Your Ref
AB/37/17/PL
Our Ref
PLAN-018096
Date
18/05/2017

Proposal: Demolition of existing dwelling & erection of 1 No. dwelling.
Site: Tahrah, Maxwell Road, Arundel, BN18 9EU.
AB/37/17/PL

Existing Plans/Sections/Elevations
 TAHRAH (formally No.1) Maxwell Road
 Arundel, West Sussex BN18 9EU
 Drg. No. EP 1

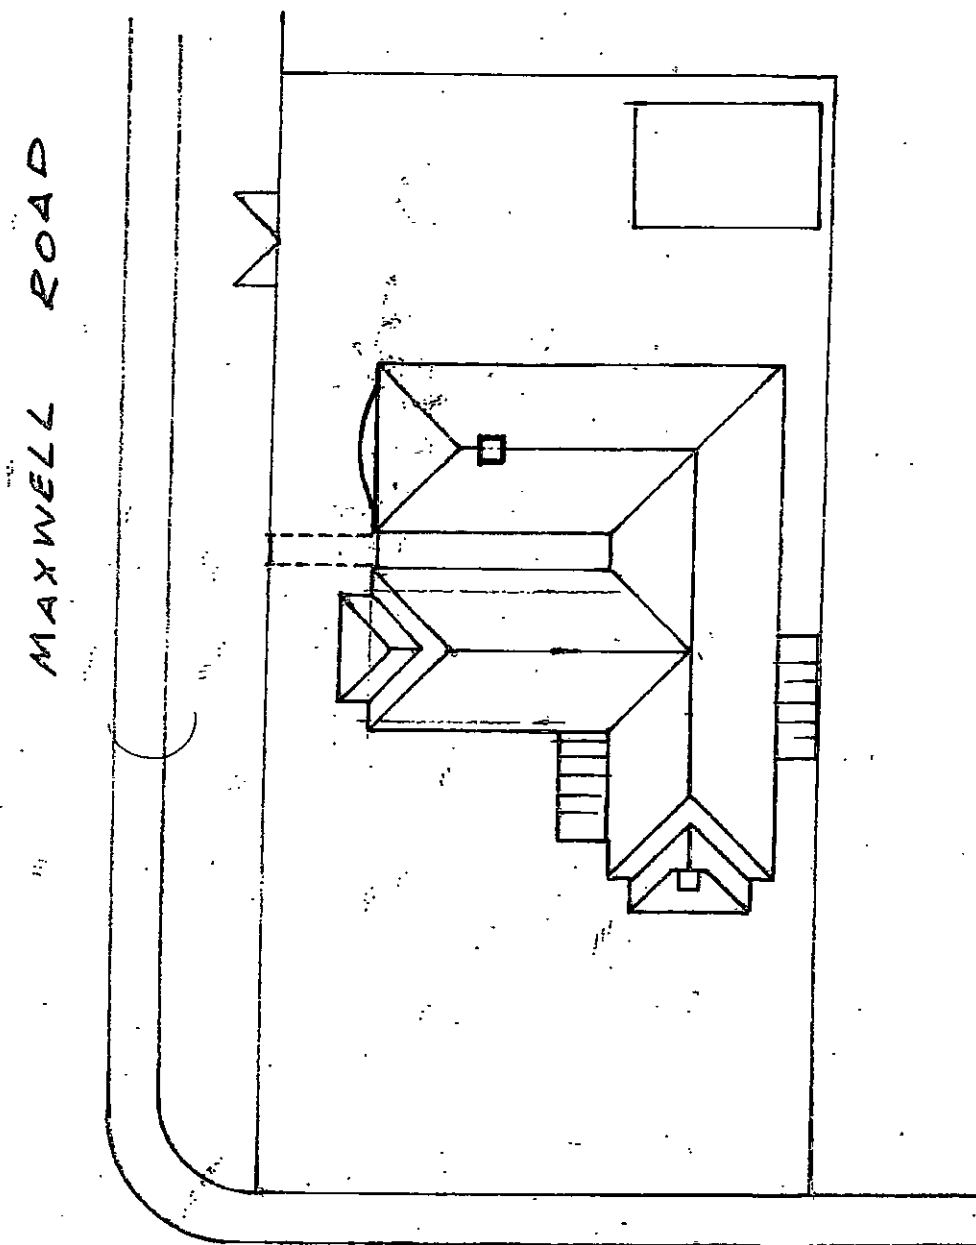
From the submitted plans it is not clear whether the existing foundations will be retained, in particular those running parallel to the existing public foul sewer.

Proposed Works to
TAHRAH (formally No.1) Maxwell Road
Arundel, West Sussex BN18 9EU
Drg. No. AB 13

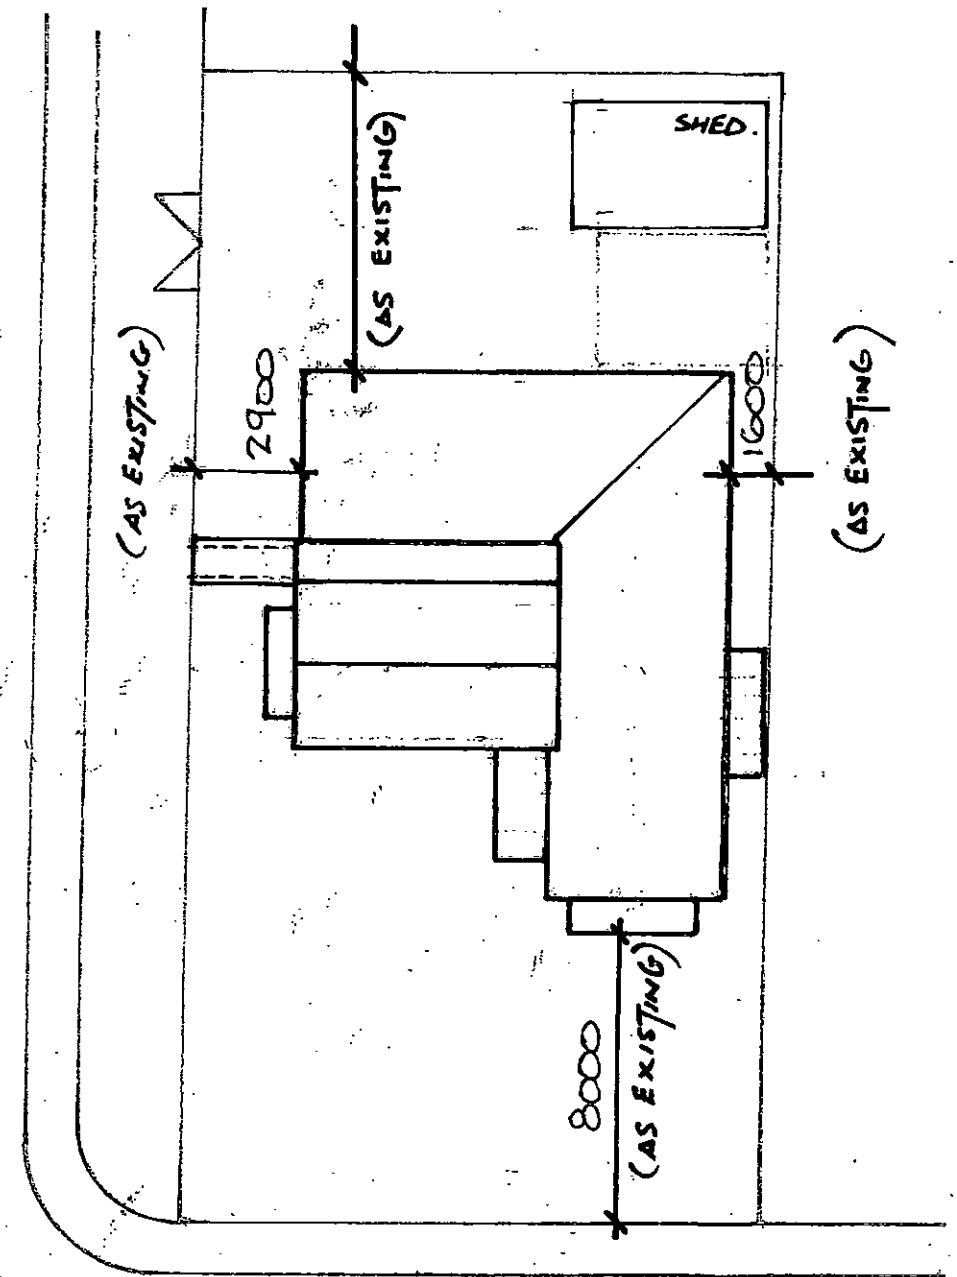
Please find attached a plan of the sewer records showing the approximate position of a public foul sewer within the site. The exact position of the public sewers must be determined on site by the applicant before the layout of the proposed development is finalised.

1. The 150 mm diameter sewer requires a clearance of 3 metres either side of the sewer to protect it from construction works and allow for future access for maintenance.
2. No development or new tree planting should be located within 3 metres either side of the centreline of the public sewer
3. No new soakaways should be located within 5m of a public sewer.
